GOVERNMENT ARCHITECT NEW SOUTH WALES

27 August 2021

PROJECT: Pymble Ladies College
RE: State Design Review Panel (SDRP) – Review 1, 18 August 2021

NORTH / SOUTH ELEVATION

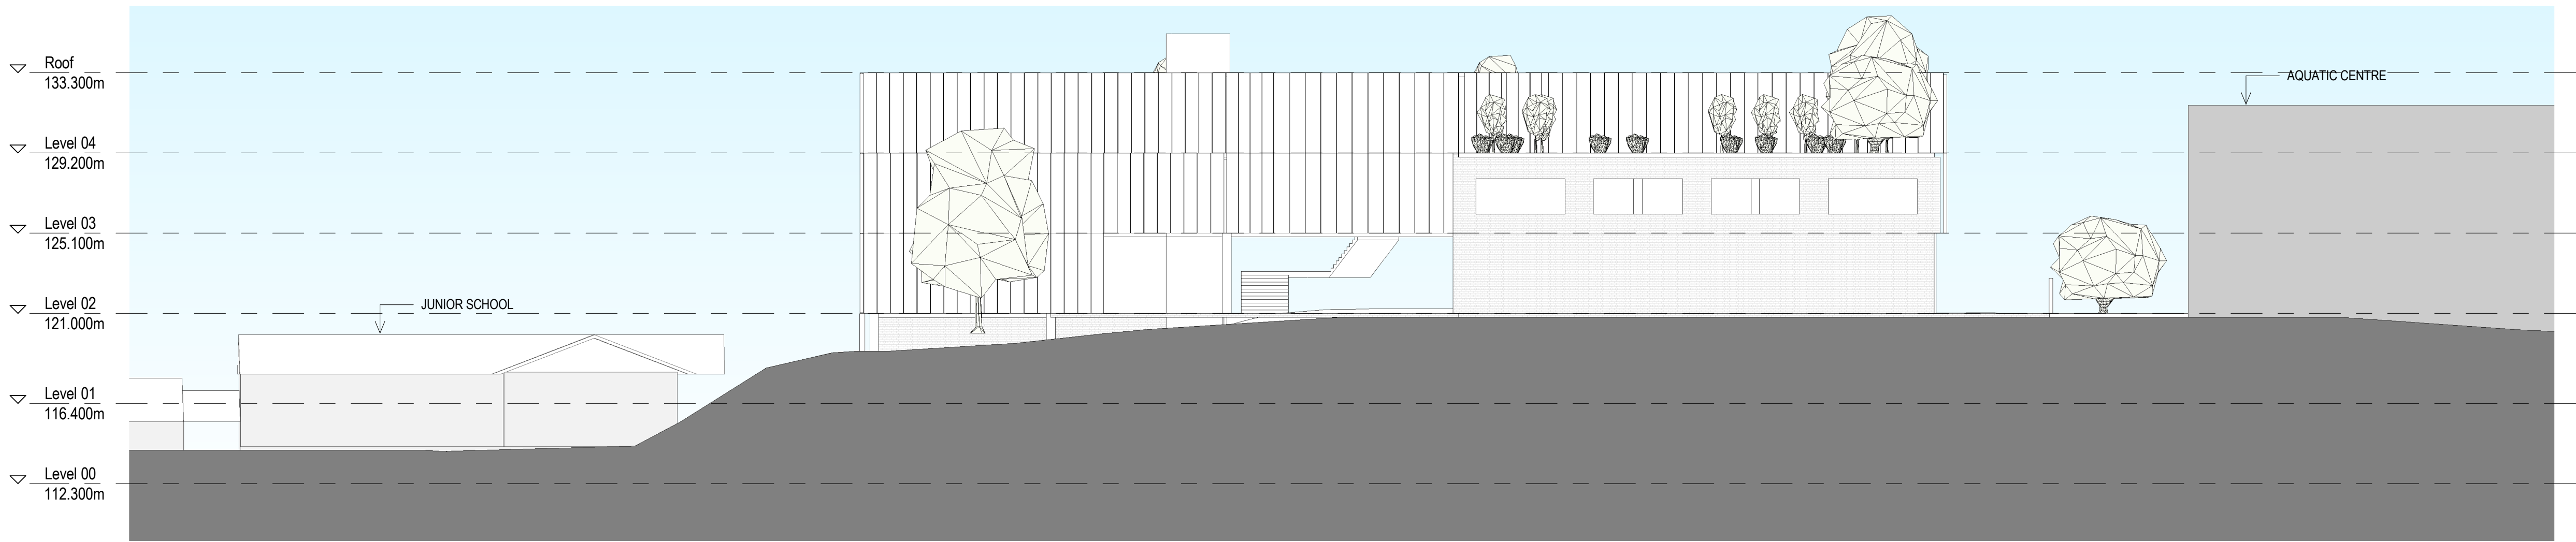
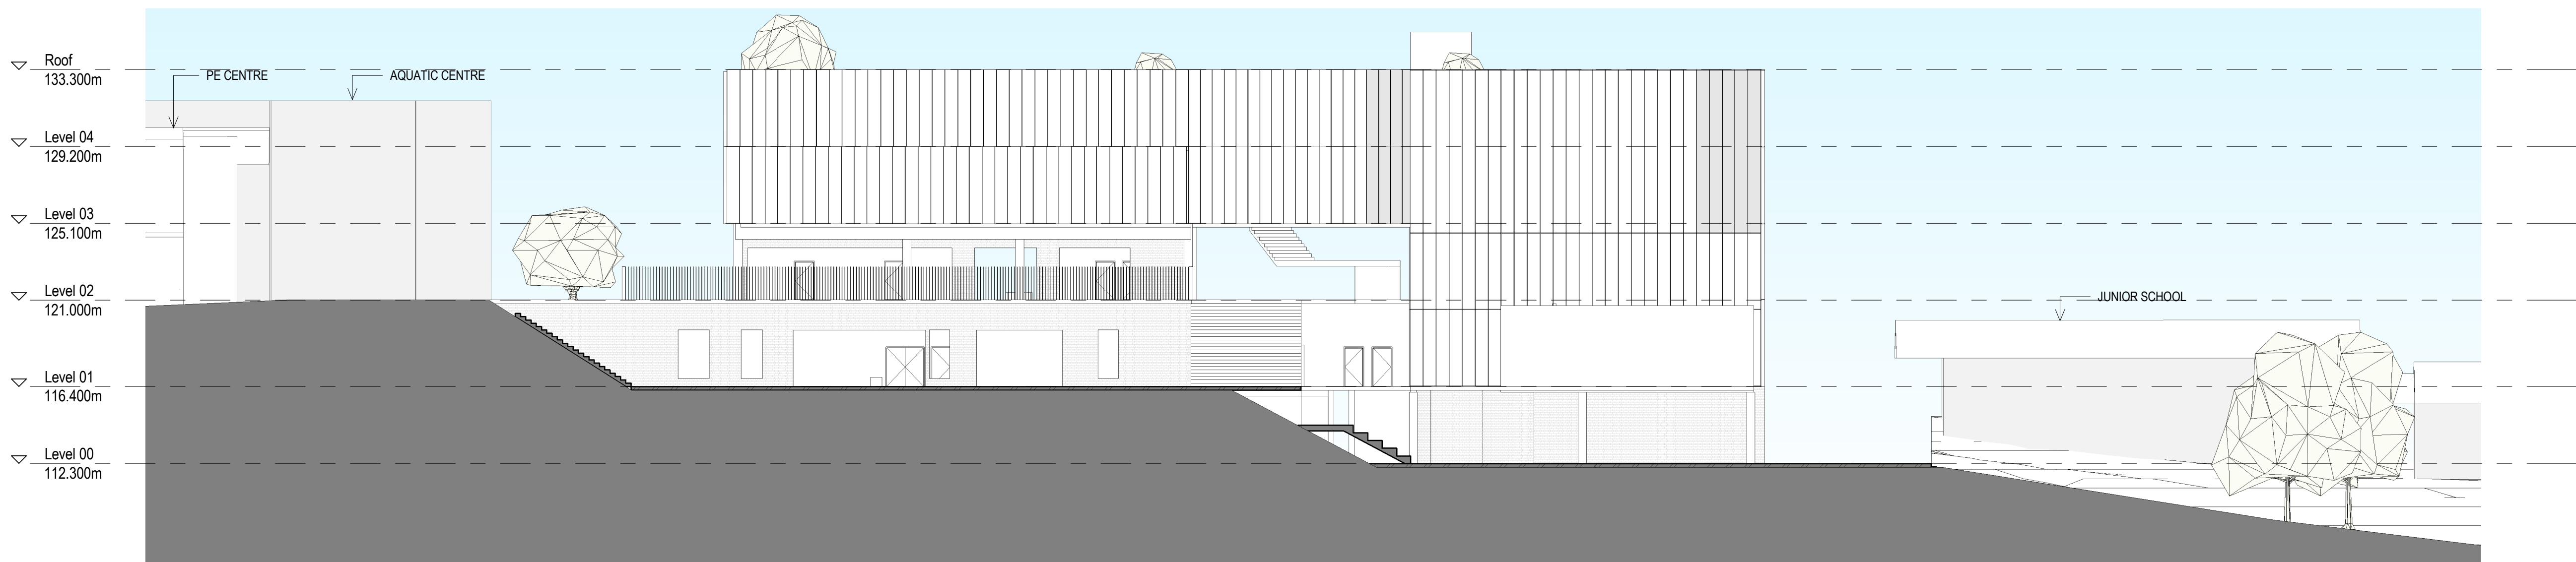
9. Review if the overshadowing of neighbours on Pymble Ave can be minimised through changes to the corners and edge of the building. Review the northern end of the new building and consider reducing the bulk and form to increase sunlight.
10. Re-examine the translation of the built form from sketch design to final design. Consider whether the architectural elegance has been lost in the formalisation and increase in scale of the building.

11. The new building has a clear formal relationship with the interior character of the site and its historic buildings. Presently this same language is carried over to the suburban side of the building that faces Pymble Ave. In relation to the previous two points, re-examine the scale, character, and architectural language of this elevation so that it might fit into its context more appropriately.
